PORTLAND MAINE

May 22, 2009

RE: 104 Front Street – 167 B006 – R-3 – handicap access ramp – permit #09-0417

104 Front St

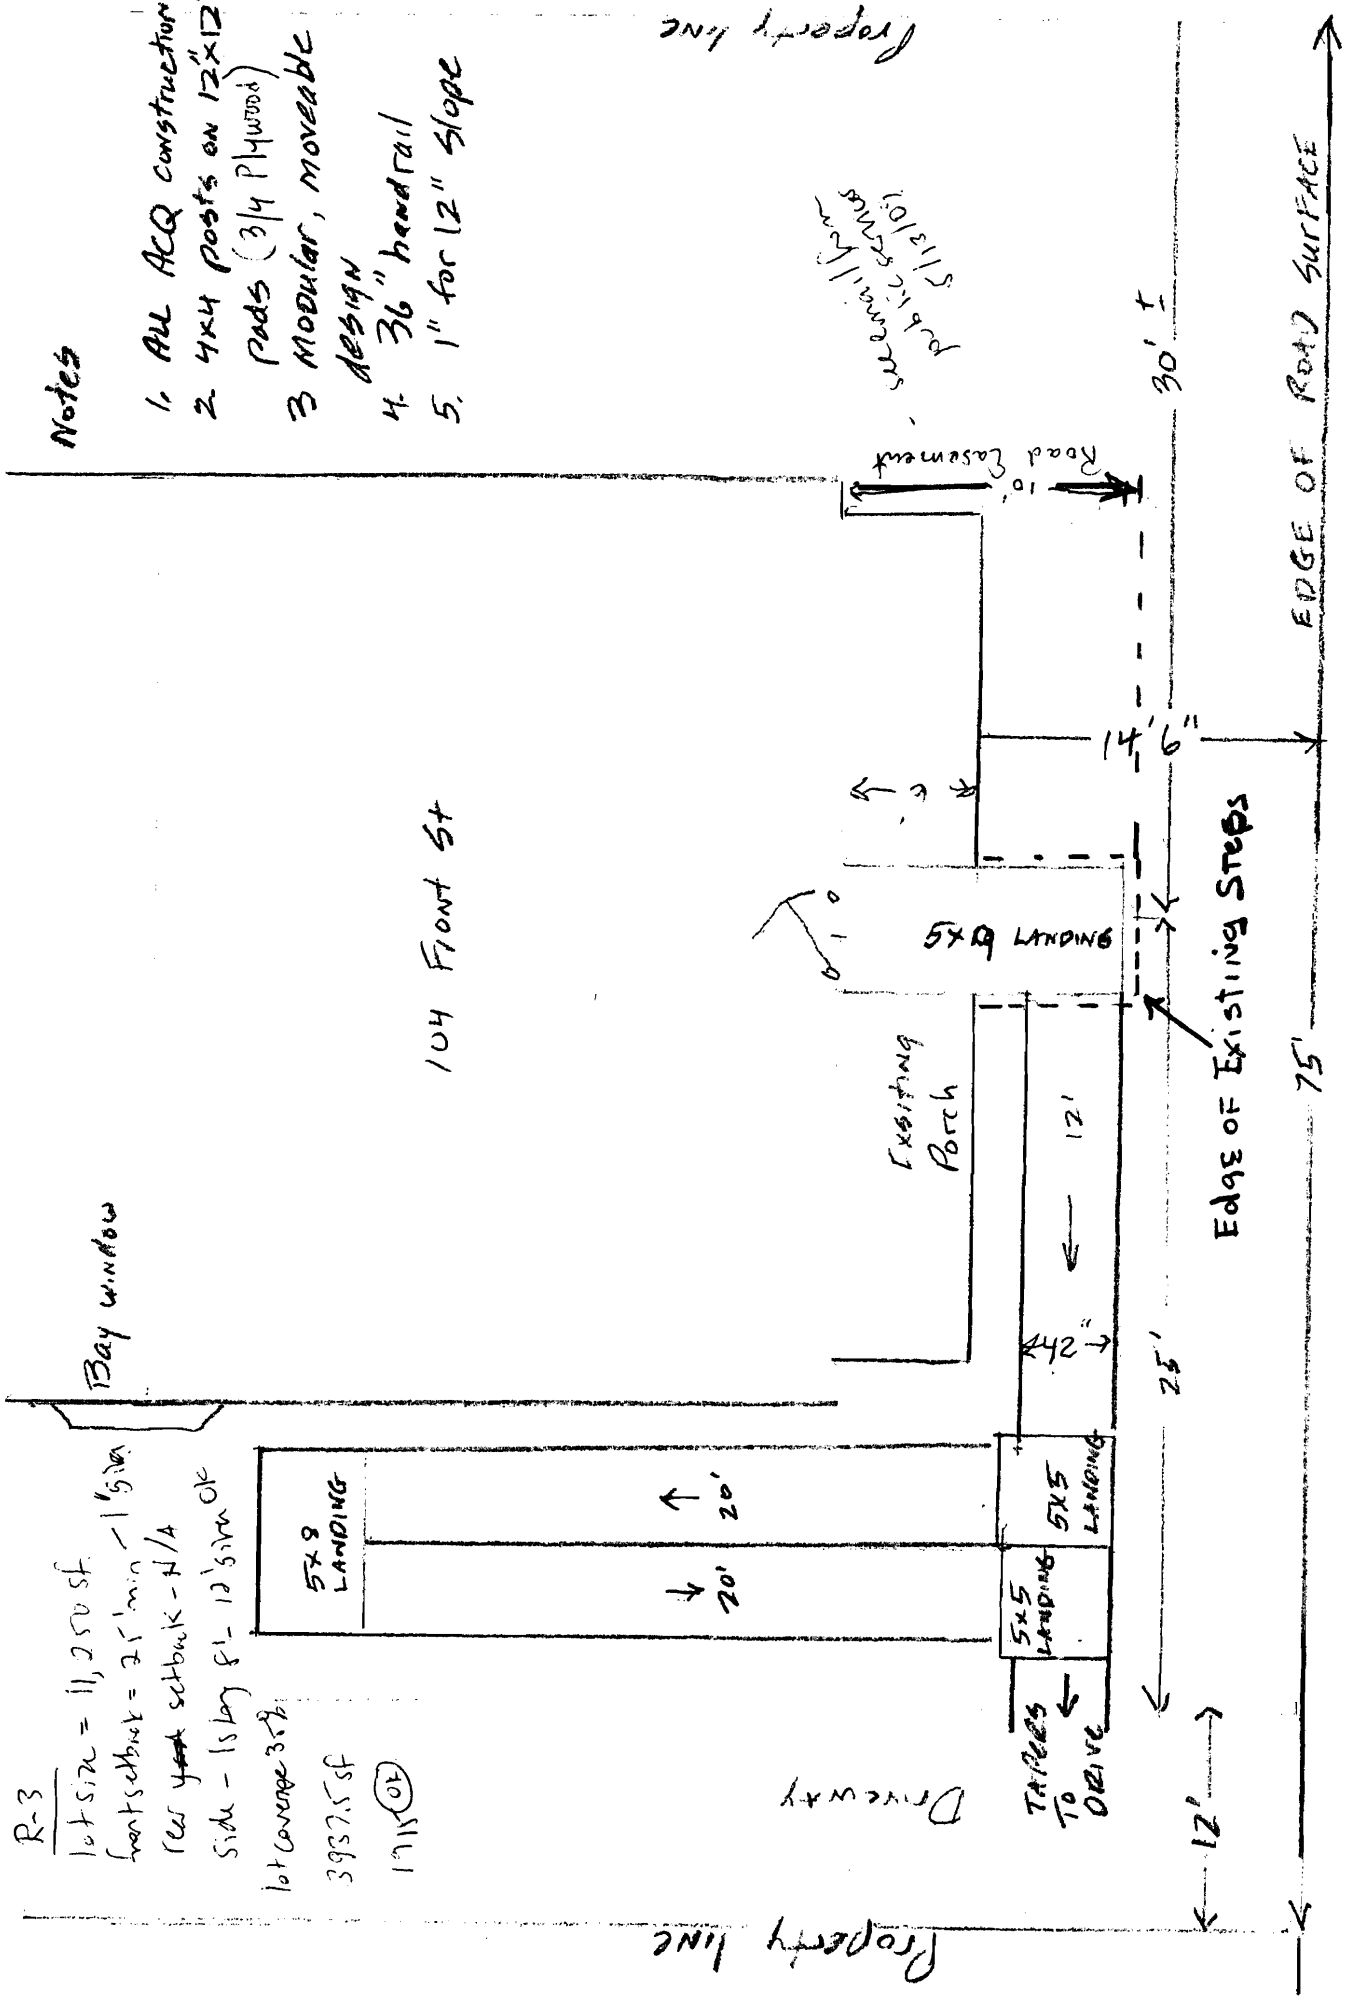
You applied to install a critical access wheel chair ramp at 104 Front Street. 104 Front Street is located in the R-3 residential zone. The front setback in the R-3 zone is twenty-five feet [section 14-90(d)(1)]. The plot plan submitted with the application gave the front yard setback to the proposed ramp as one foot, so it does not meet the required setback. Since the handicap ramp has to be installed ASAP, we will move the permit forward, but you need to apply for a disability variance within thirty days of the permit being issued, since the ramp does not meet the required front setback.
